CITY OF ALBUQUERQUE

December 19, 2019

RE: 833 Dolores Dr. NW
Grading and Drainage Plan
Engineer's Stamp Date: 12/13/19
Hydrology File: J11D040

ENGINEER'S SEAL	833 DOLORES DR. GRADING AND DRAINAGE PLAN	DRAWN BY DEM
DAVID SOULE P.E. #14522		DATE 12-12-19
	 1608 CENTRAL AVENUE SE SUITE 201 ALBUQUERQUE, NM 87106 (505) 972-0899	833 DOLORES.DWG
		SHEET # C1
		JOB #

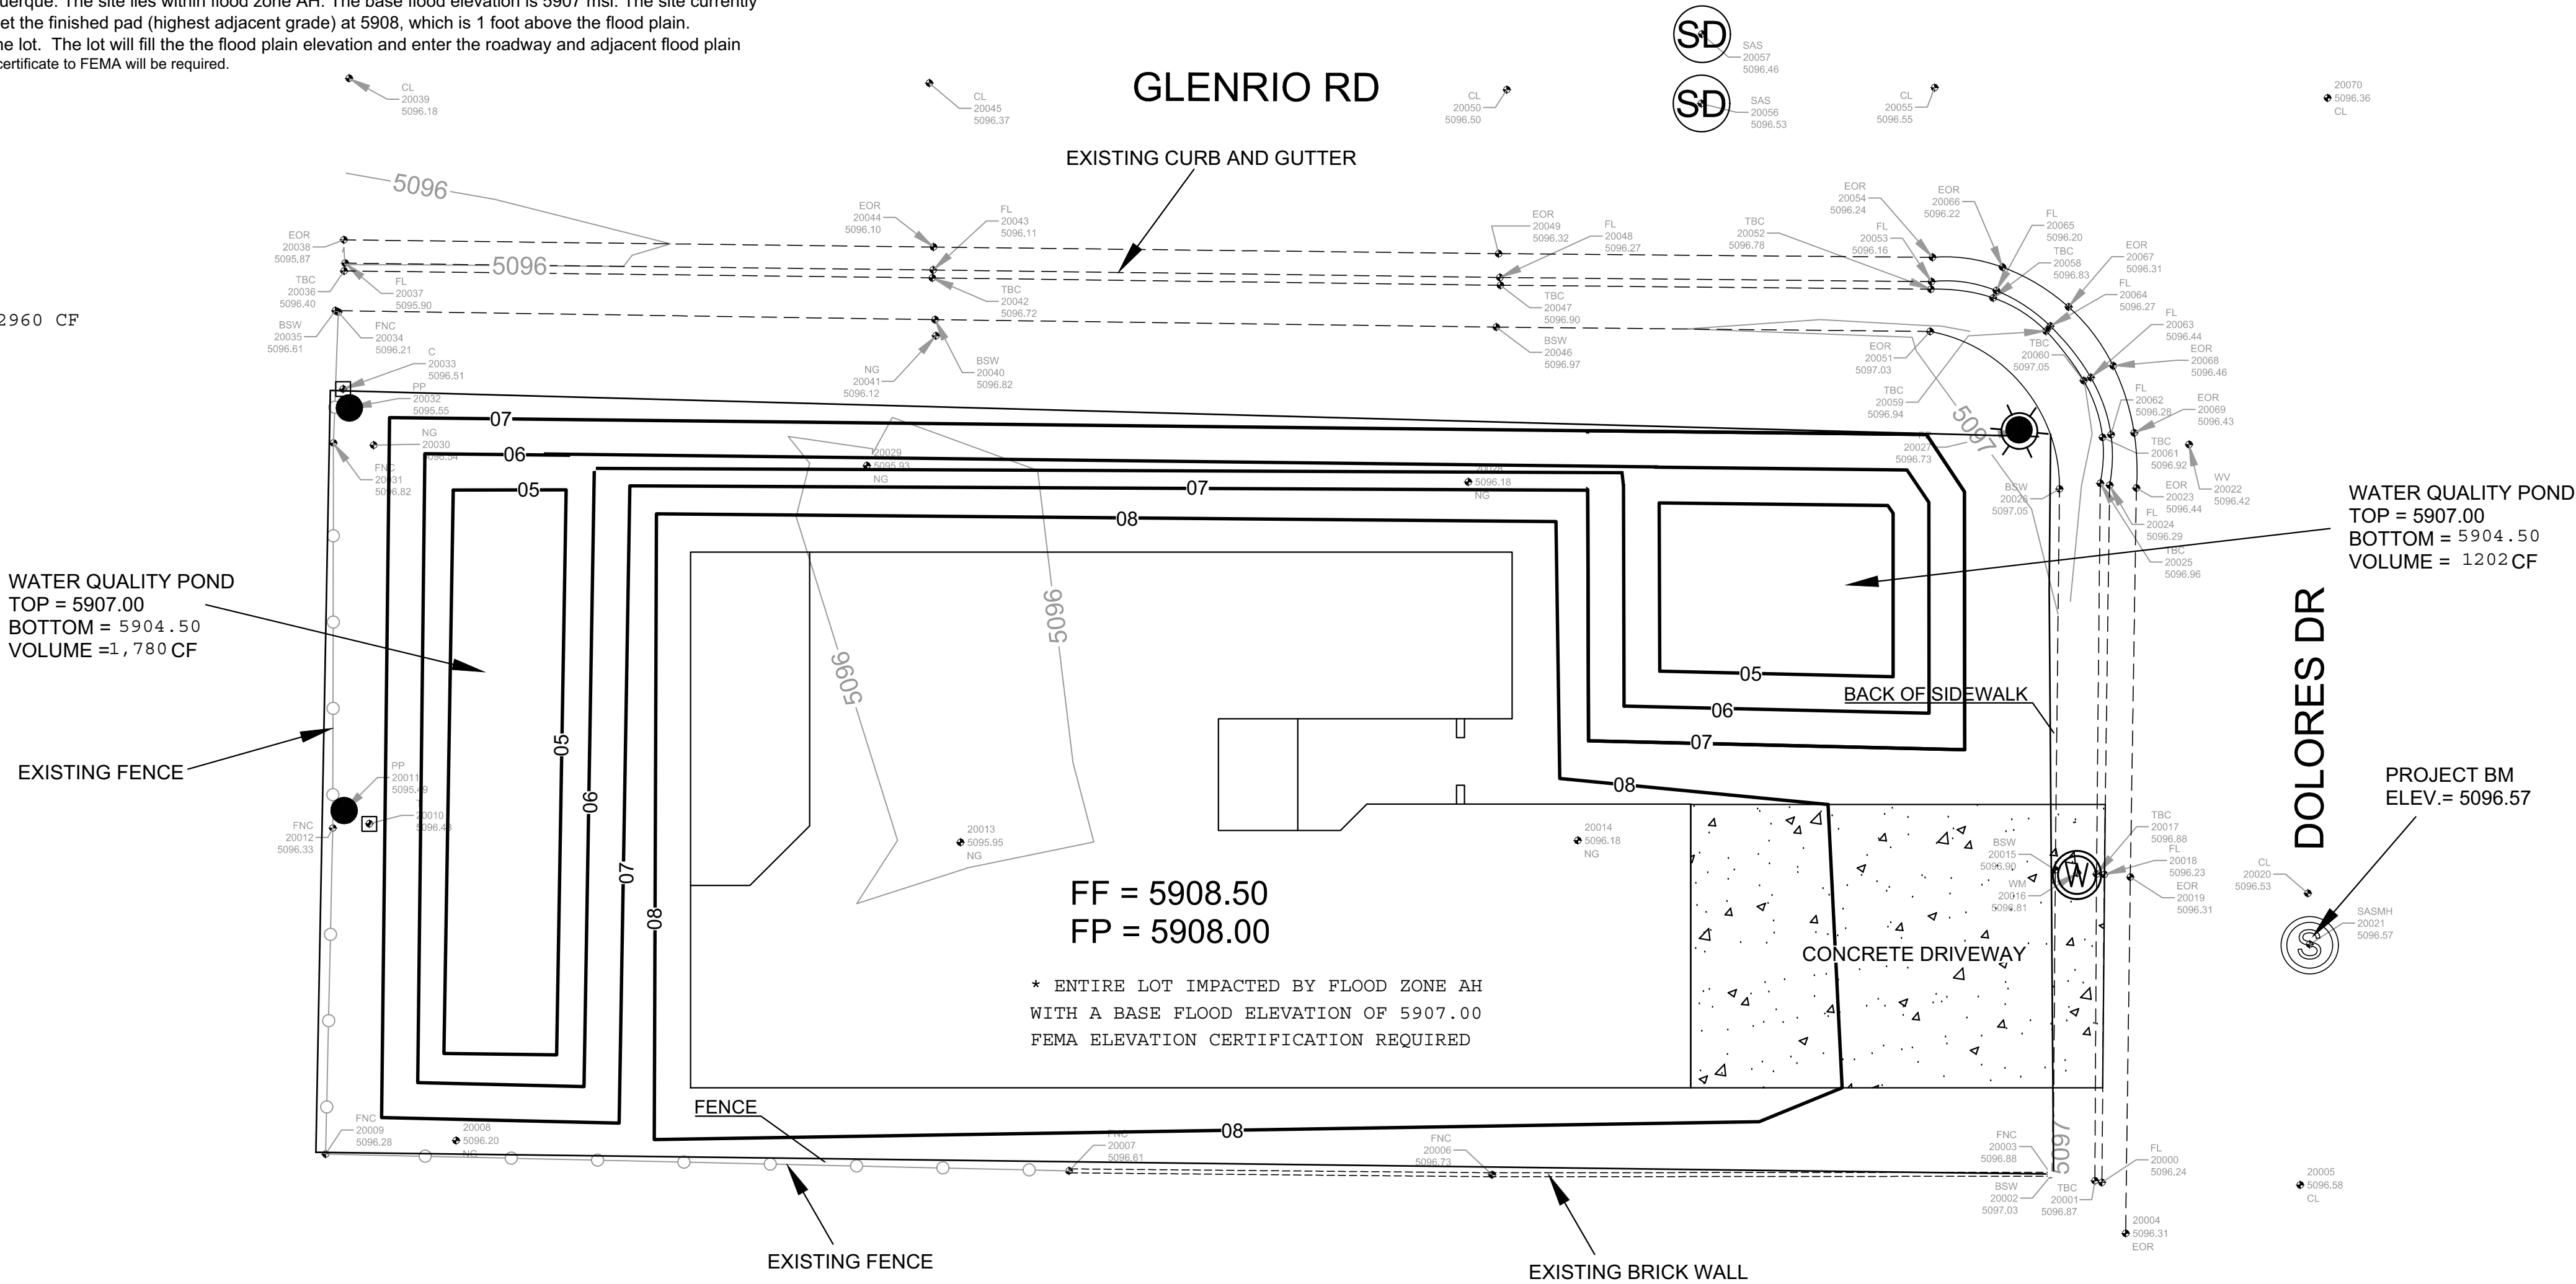
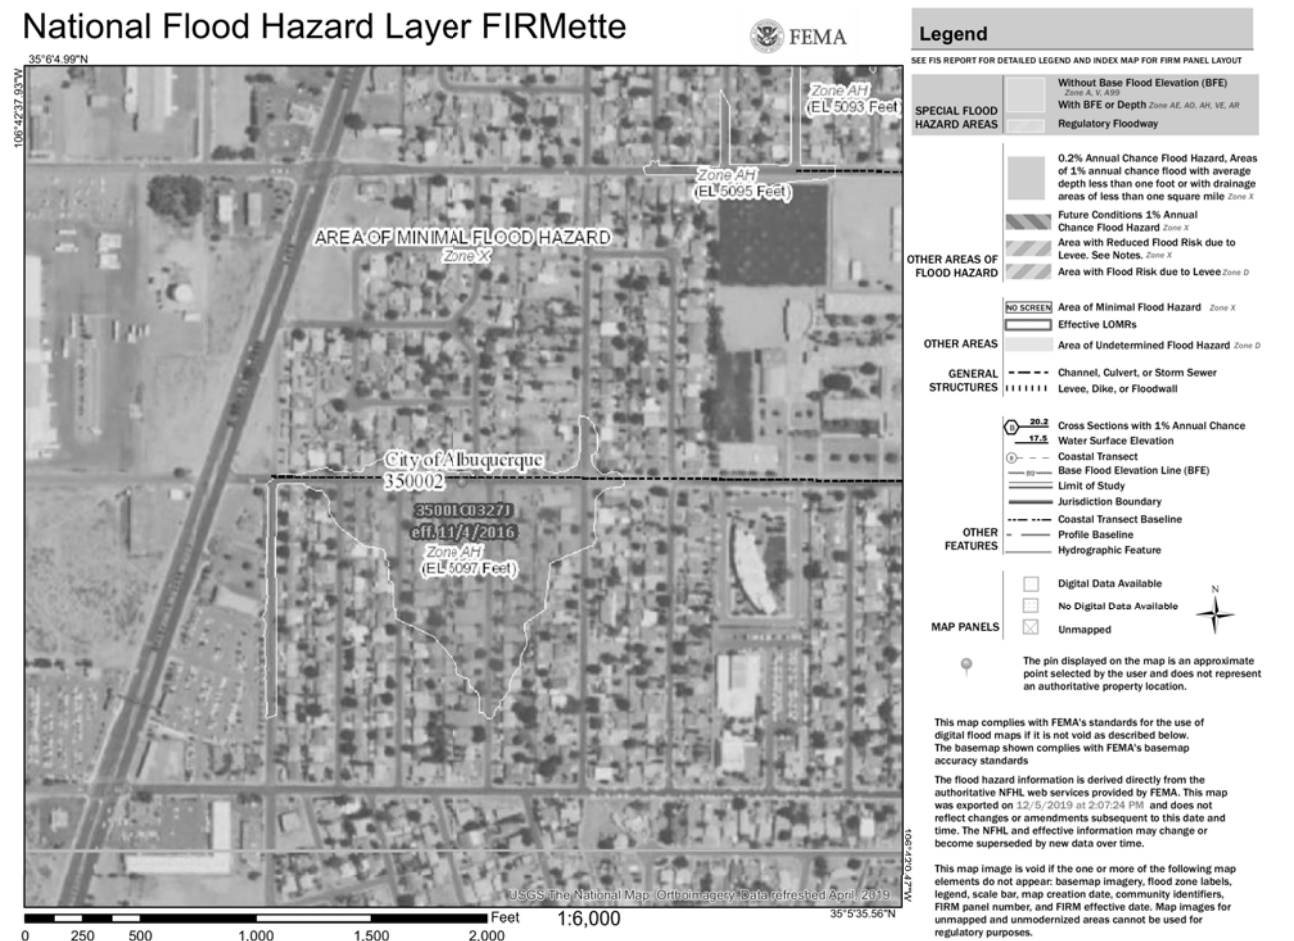
1. As stated on the plans, this site is located in a floodplain (AH – Elev 5907) and must have a floodplain development permit prior to issuing the Building Permit. The permit application must demonstrate zero rise to the base flood elevation, unless a Letter of Map Revision (LOMR) is being prepared. Please contact Rudy Rael, CFM for more information regarding floodplain development permits (rrael@cabq.gov or 924-3977).
2. Since this needs only needs a floodplain development permit, an administration fee of \$40 will be required at the time of resubmittal.
